3 August 2022

AMENDMENT TO SSD-9522 KEMPS CREEK ESTATE – MODIFICATION 3

s37 Request to amend SSD-9522 MOD 3

FUNCTIONAL LAYOUT PLAN-MOD 4 CUL-DE-SAC/BAKERS LANE
1:250 SCALE

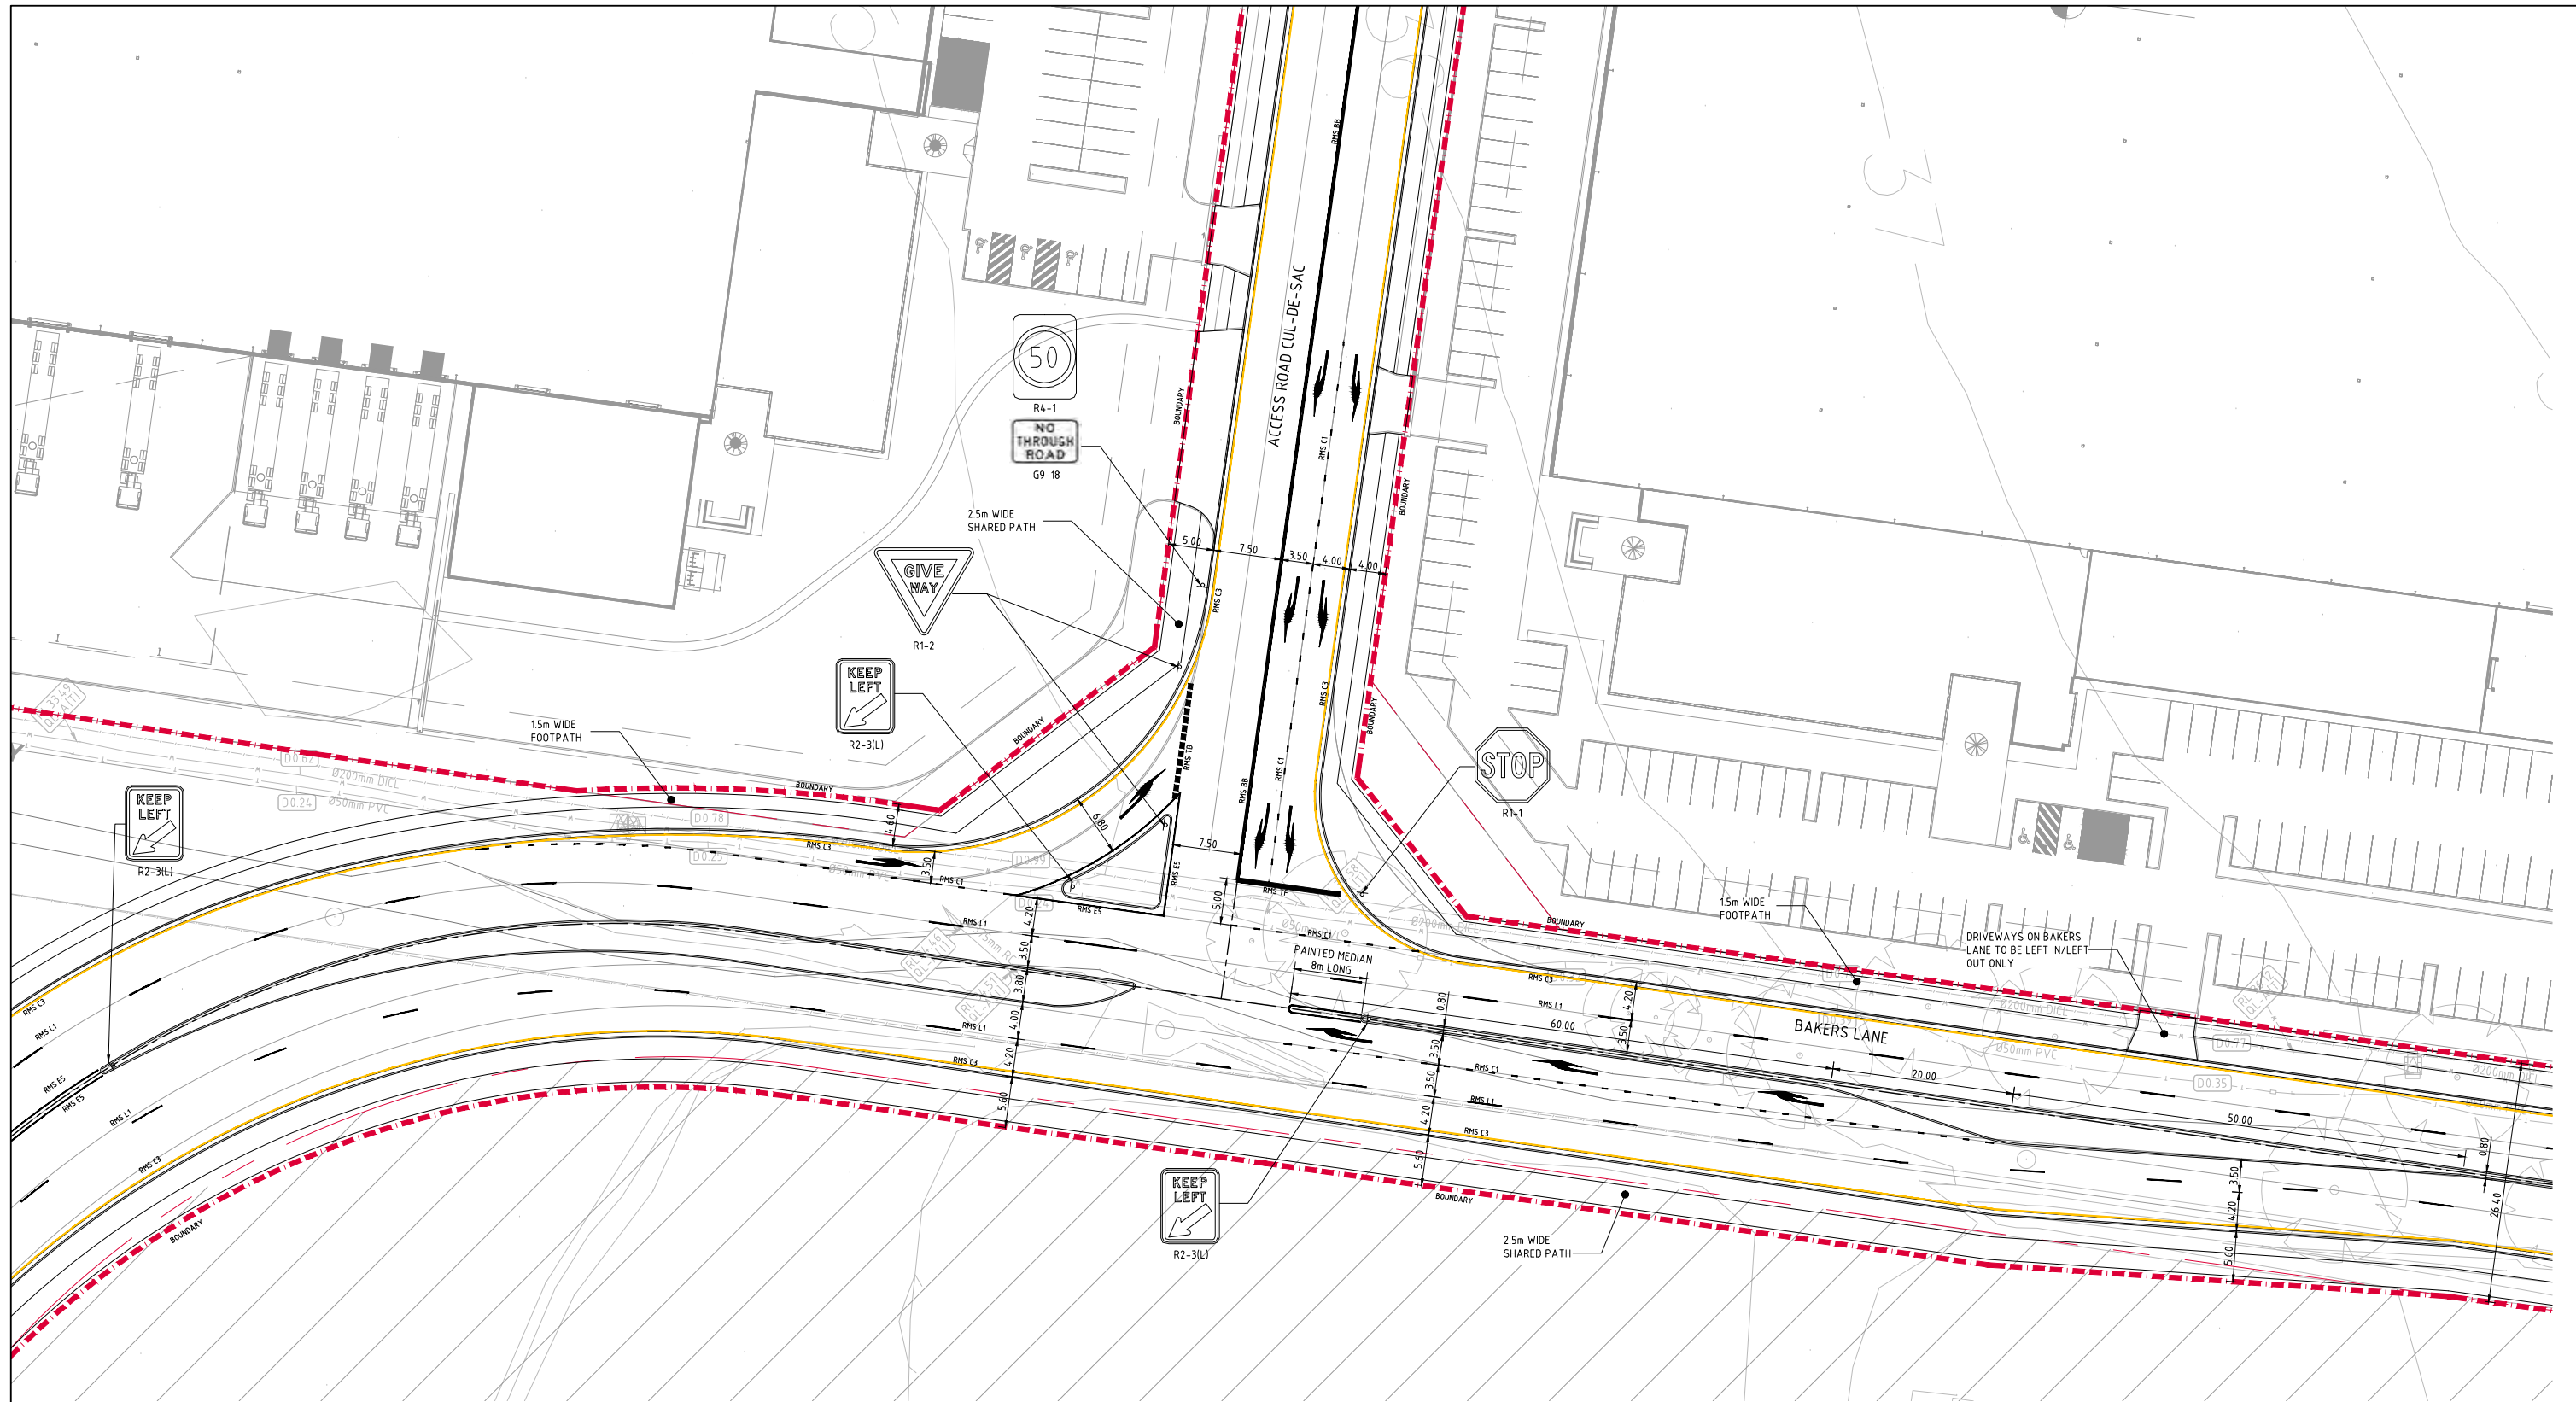
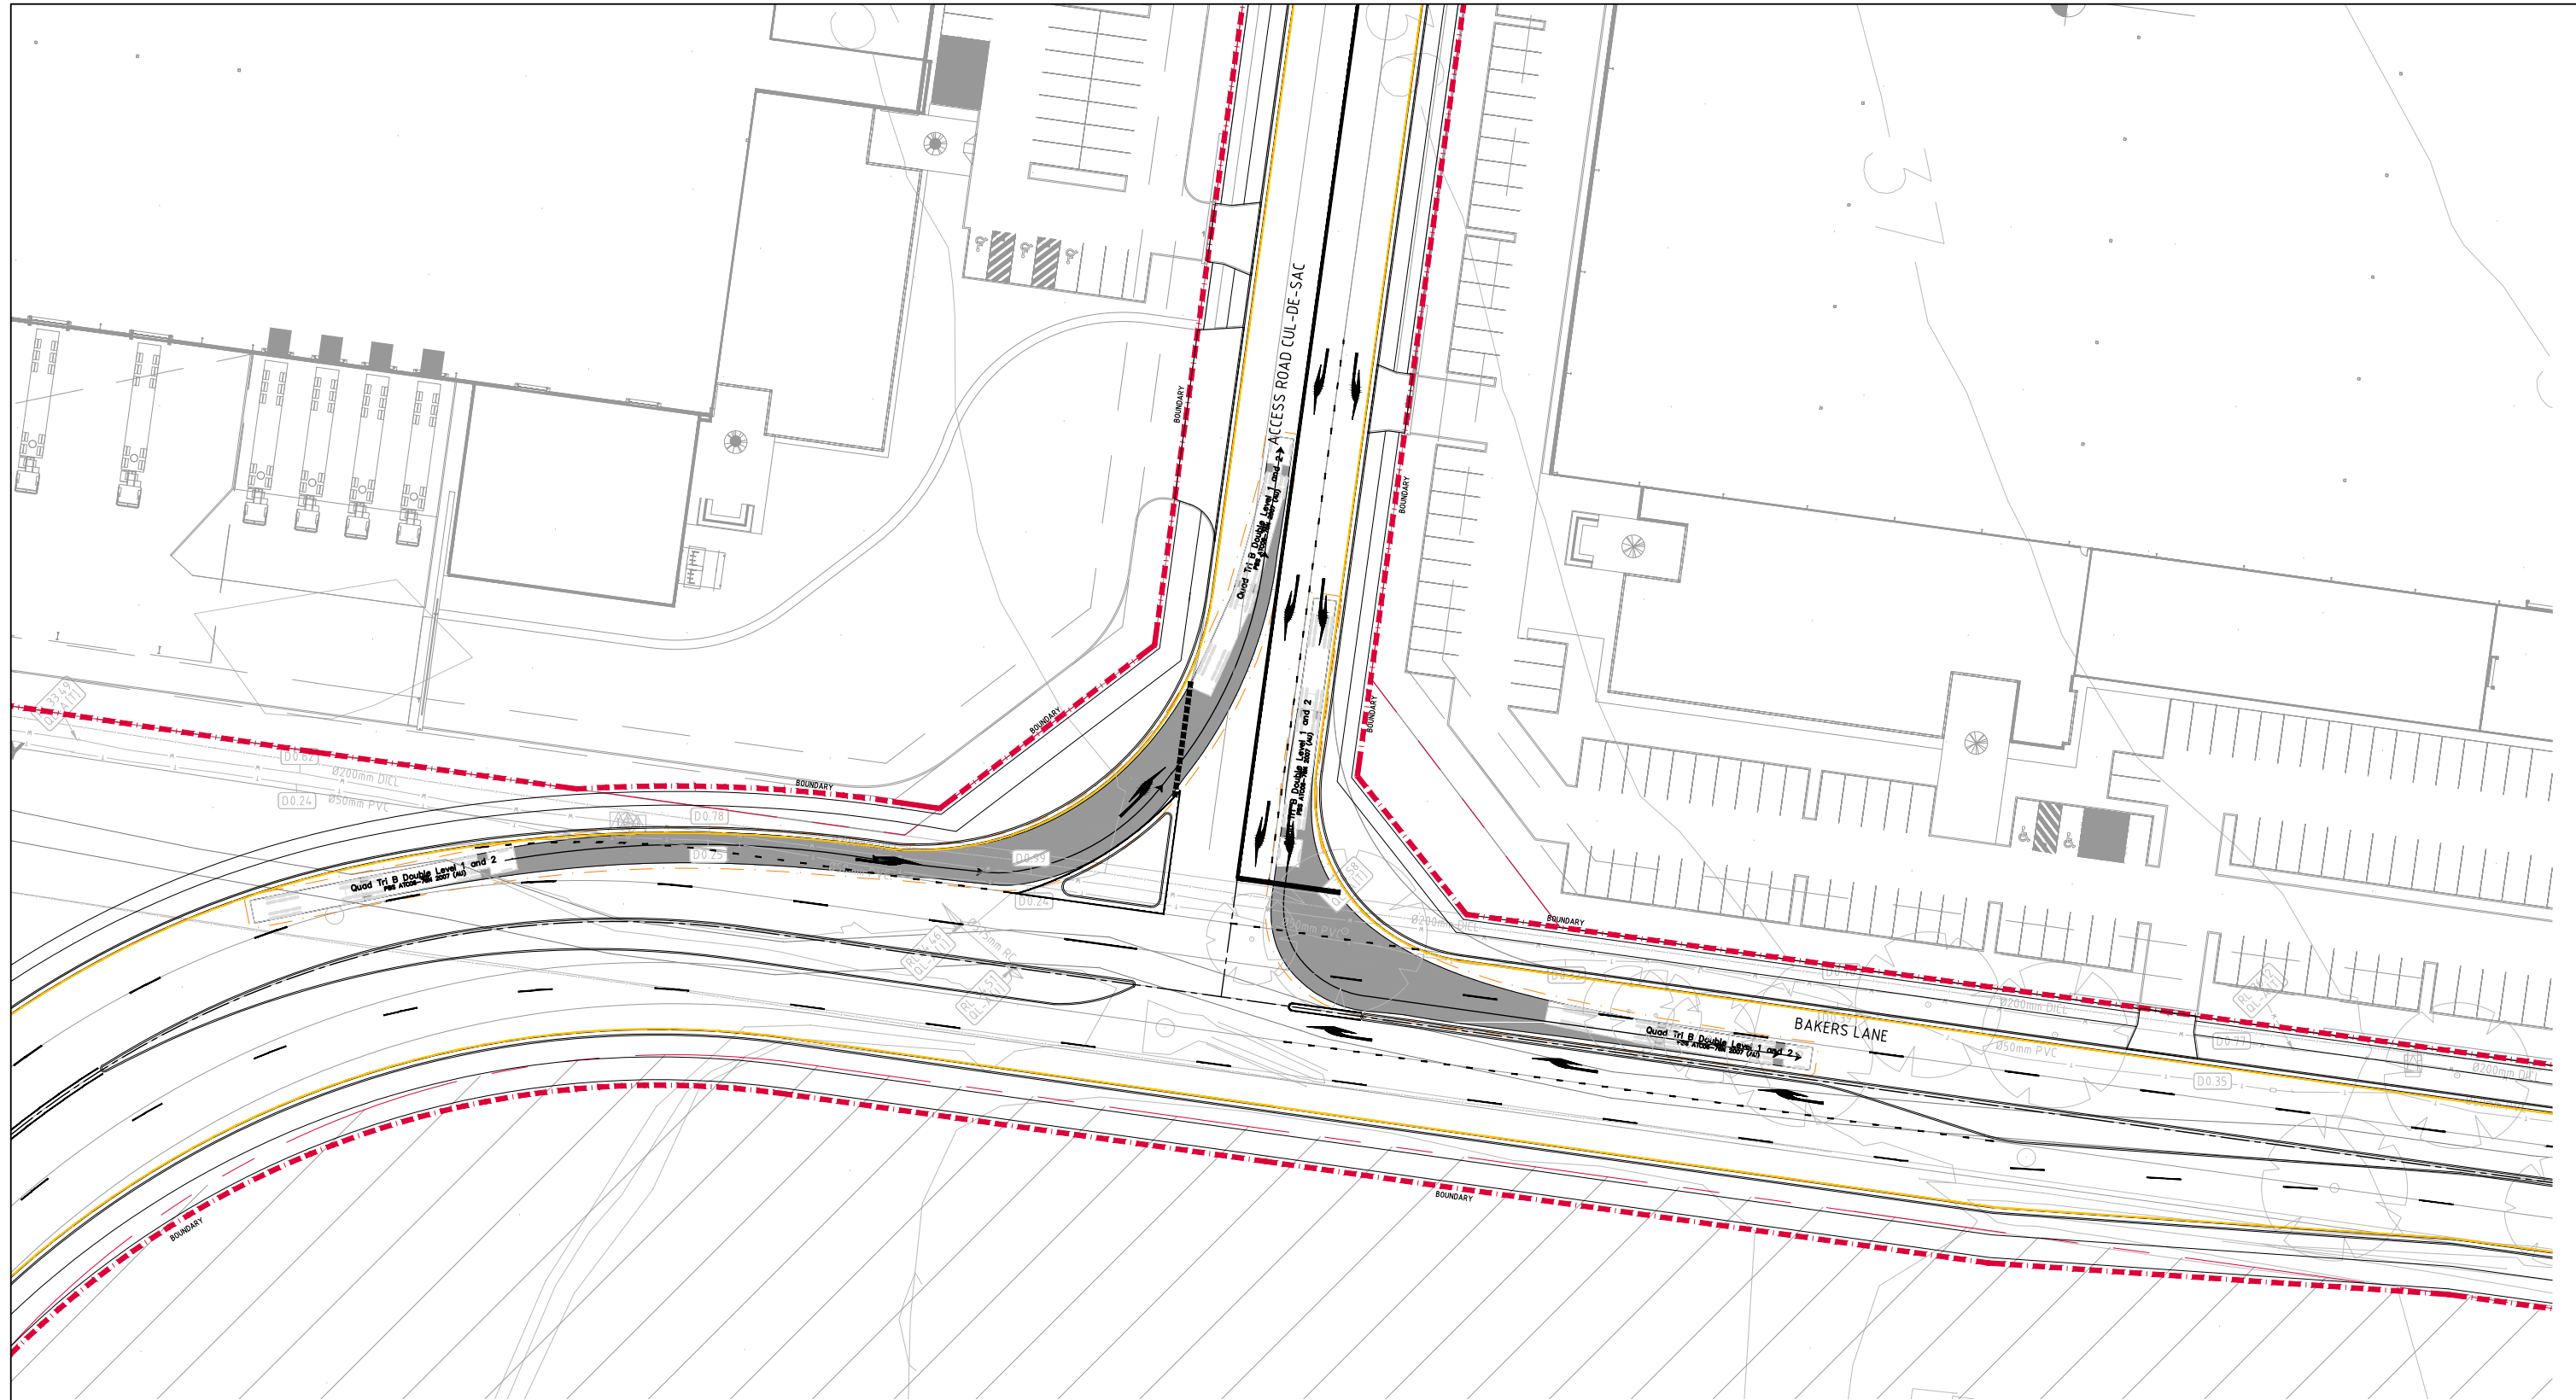
- The proposed development on Lots 2 and 3 will remain unchanged.
- Removal of the north south one-way directional access road, which is in the form of cul-de-sac, proposed within the centre of Lots 1-4.

- The cul-de-sac will be replaced with a private access road which will provide access to Lots 2 and 3. The private access road will provide driveway access to Lots 2 and 3 (refer Figure 5).

- The location of the new access road results in:
 - inadequate sight distance on approach to the intersection with Southern Link Road (SLR) intersection;
 - below standard horizontal geometry for the northbound through movement;
 - angled pedestrian crossings;
 - high angled and tight swept paths
- TfNSW has requested that the location of the new access road should be as close to 90 degrees with the SLR as possible.
- TfNSW has requested that any design for the new access road will need to ensure a double diamond can be achieved.
